***MODIFICATION REQUEST:
Residential Development
2 Cooper Street, Paddington
(MP10_0016 MOD 1)***

Amend conditions to correct minor errors; and to replace a requirement for underground power lines with aerial bundle cabling

Secretary's Environmental Assessment Report
Section 75W of the
Environmental Planning and Assessment Act 1979

March 2015

ELECTRICAL SERVICES
EXTERNAL SITE PLAN

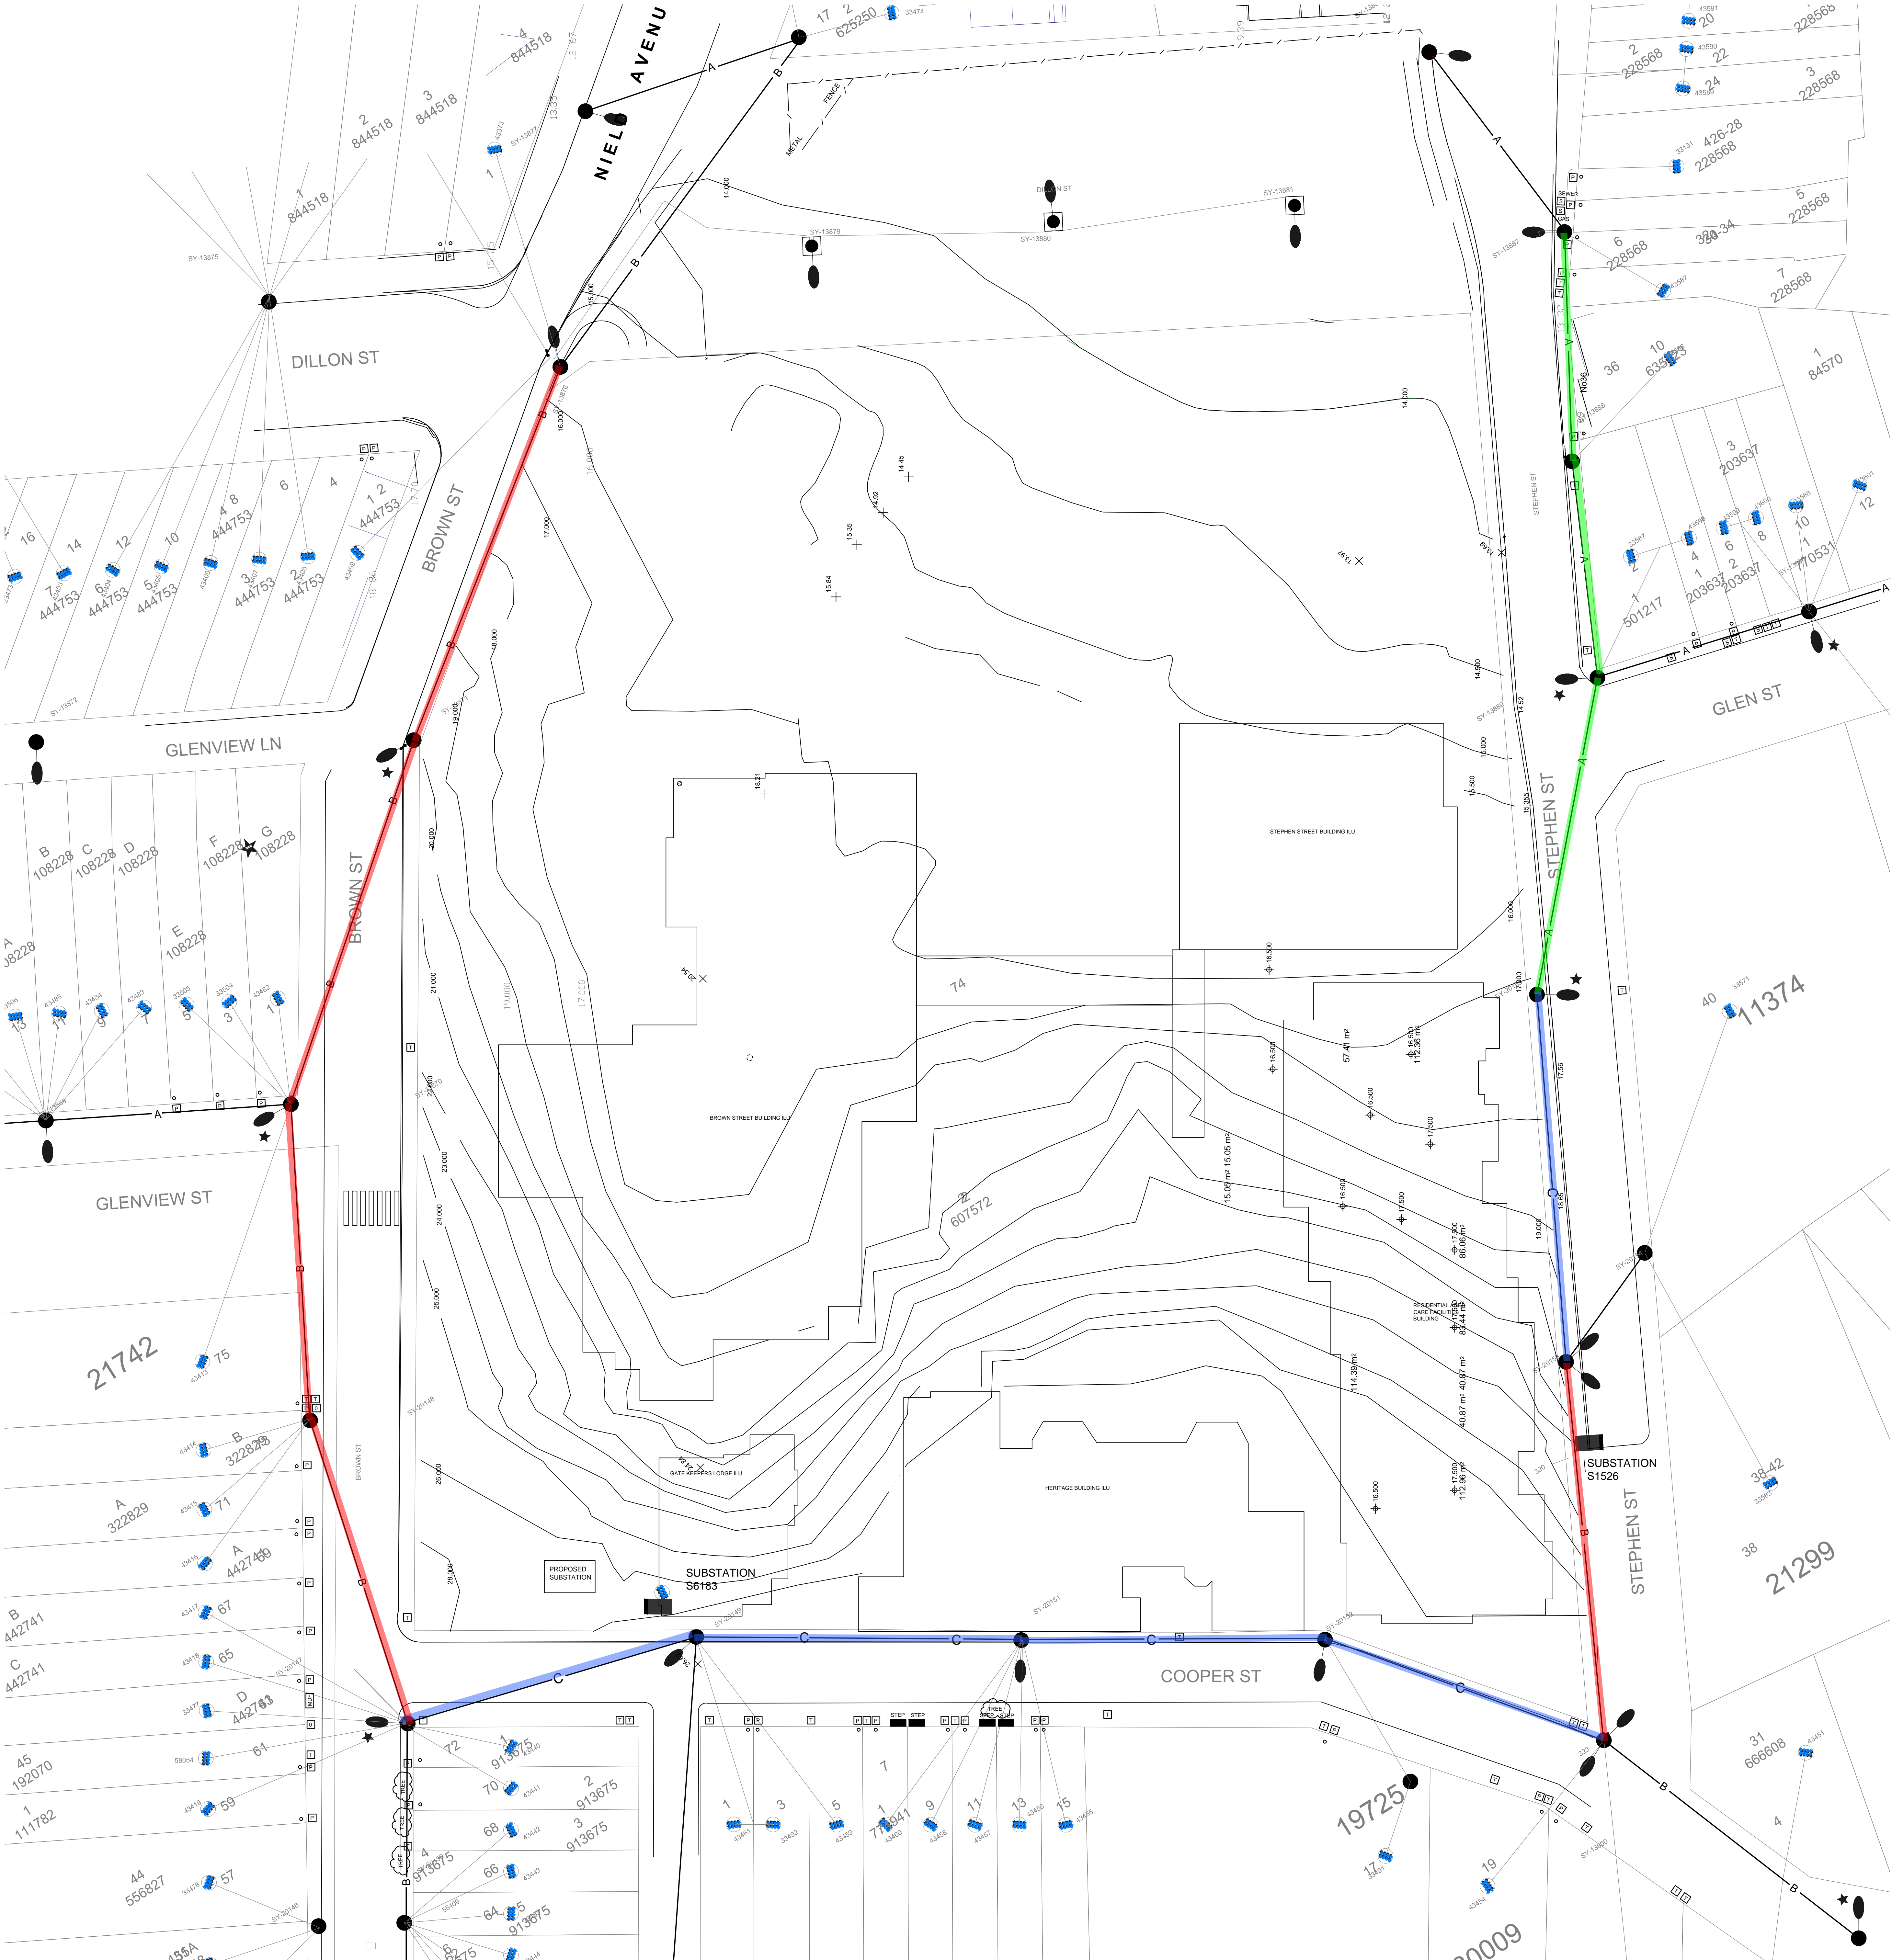
The Proponent has been in discussions with Ausgrid in relation to complying with Condition E17 and has advised that Ausgrid has no current plans to underground power lines in the locality. Further Ausgrid have recently undertaken aerial bundling of overhead cables (referred to as ABC) along Brown and Stephen Streets, which involves four existing bare power cables replaced with a single bundled cable. Existing and proposed bare and aerial bundled cabling along frontages to the subject site are shown in **Figure 2** over page).

The proposal therefore seeks to amend Condition E17 to delete the requirement to underground power and telecommunication facilities, and replace it with the requirement to undertake aerial bundling of existing power lines. In effect, the proposed condition would require that the existing bare aerial cabling located along the Cooper and Stephen Streets frontages of the site be reconfigured to ABC.

The proposed aerial bundling of power lines in Cooper and Stephen Streets is consistent with the work already undertaken by Ausgrid along the Brown Street frontage of the site and can be provided without any impacts on the streetscape and pedestrian amenity and accessibility surrounding the site. The Department notes that existing bare aerial cables will remain on the eastern side of Stephen Street as they are outside of the frontage of the site.

The Department therefore supports the proposed amendment to Condition E17.
